BELMORGAN PROPERTY DEVELOPMENT

DWYERS SITE

STAGE 1 ACCESSIBILITY REVIEW

25th September 2007

DRAWING NO. A-DA-2.10

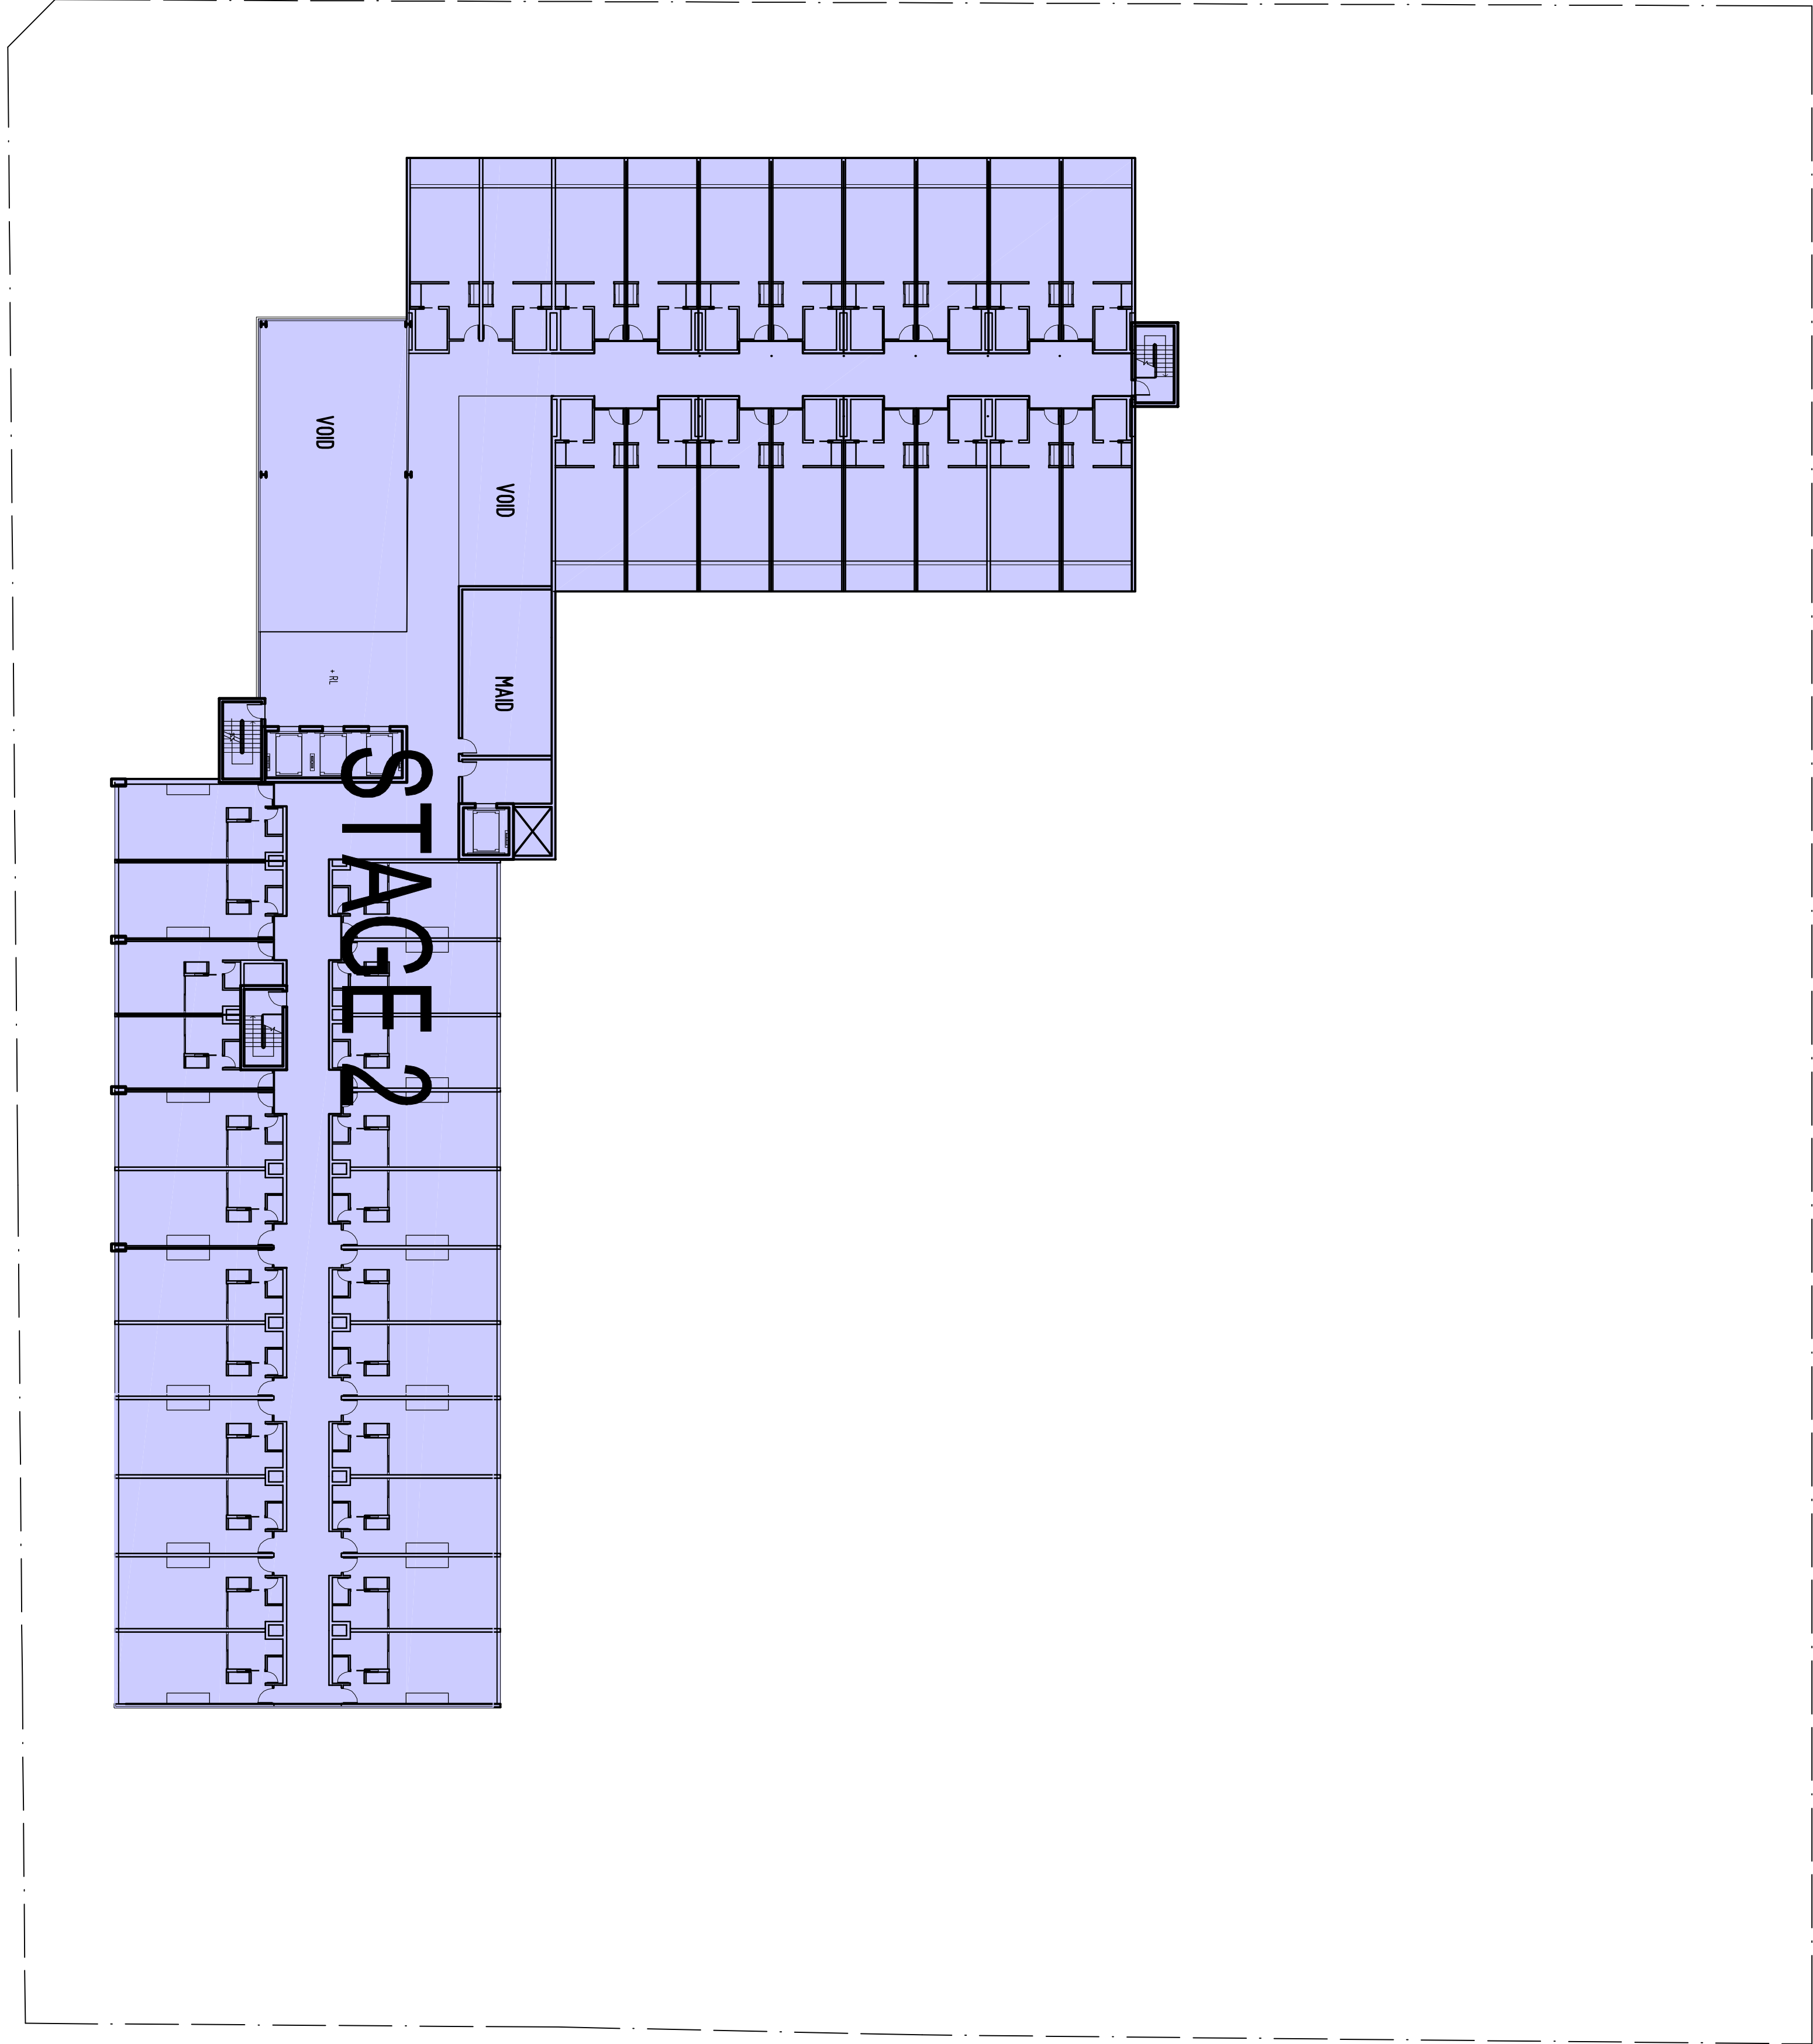
-
- (ix) In the 4 restaurants with mezzanines, widen stairs to 1500mm to allow future installation of stair platform lift
 - (x) The BCA requires that 8 hotel rooms are accessible. The draft DDA Premises Standards requires 9 accessible guest rooms.

From the information provided, there are 198 guest rooms. The current layout of guest room cannot accommodate the circulation areas required for an accessible guest room.

DRAWING NO. A-DA-2.05 G

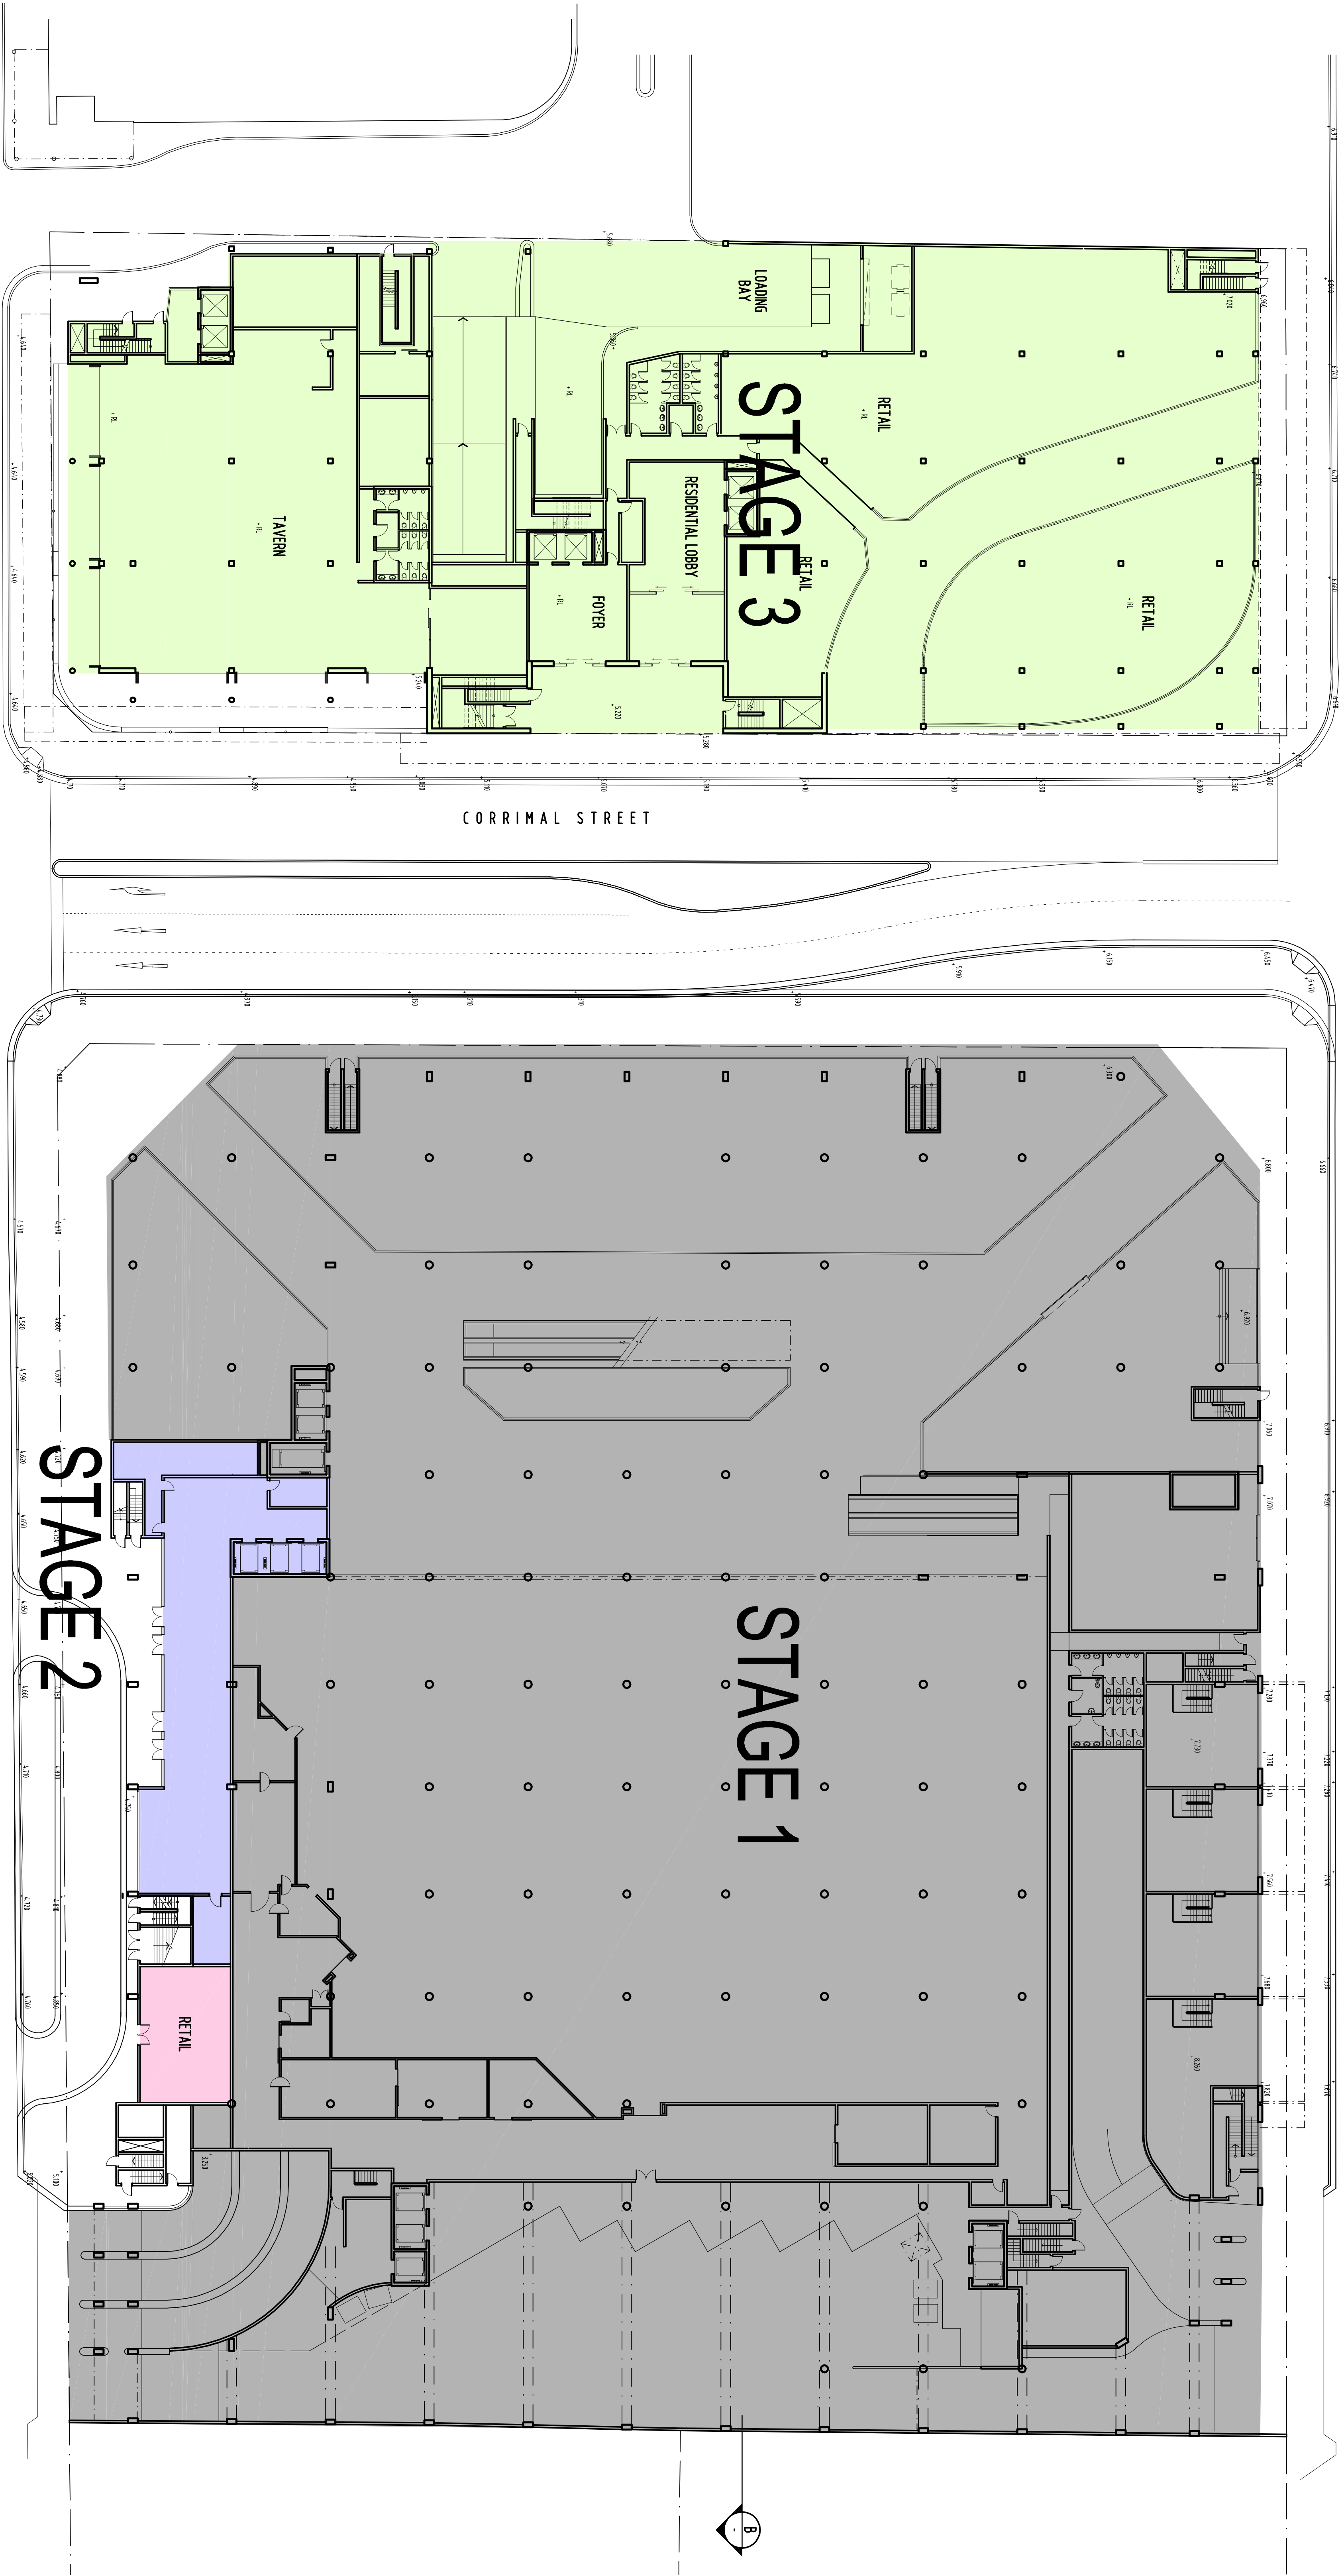
- (iii) Retail entry stair from Crown Street needs handrails in accordance with AS1428.1 and tactile ground indicators in accordance with AS1428.4. Signage to be provided to other main entrance within Mall.

There are 5 restaurants on level 1 which appear to be directly accessed from Crown Street. The 5 restaurants appear to have access to and within the ground level of each restaurant. There is no wheelchair access to the mezzanine levels in these restaurants.
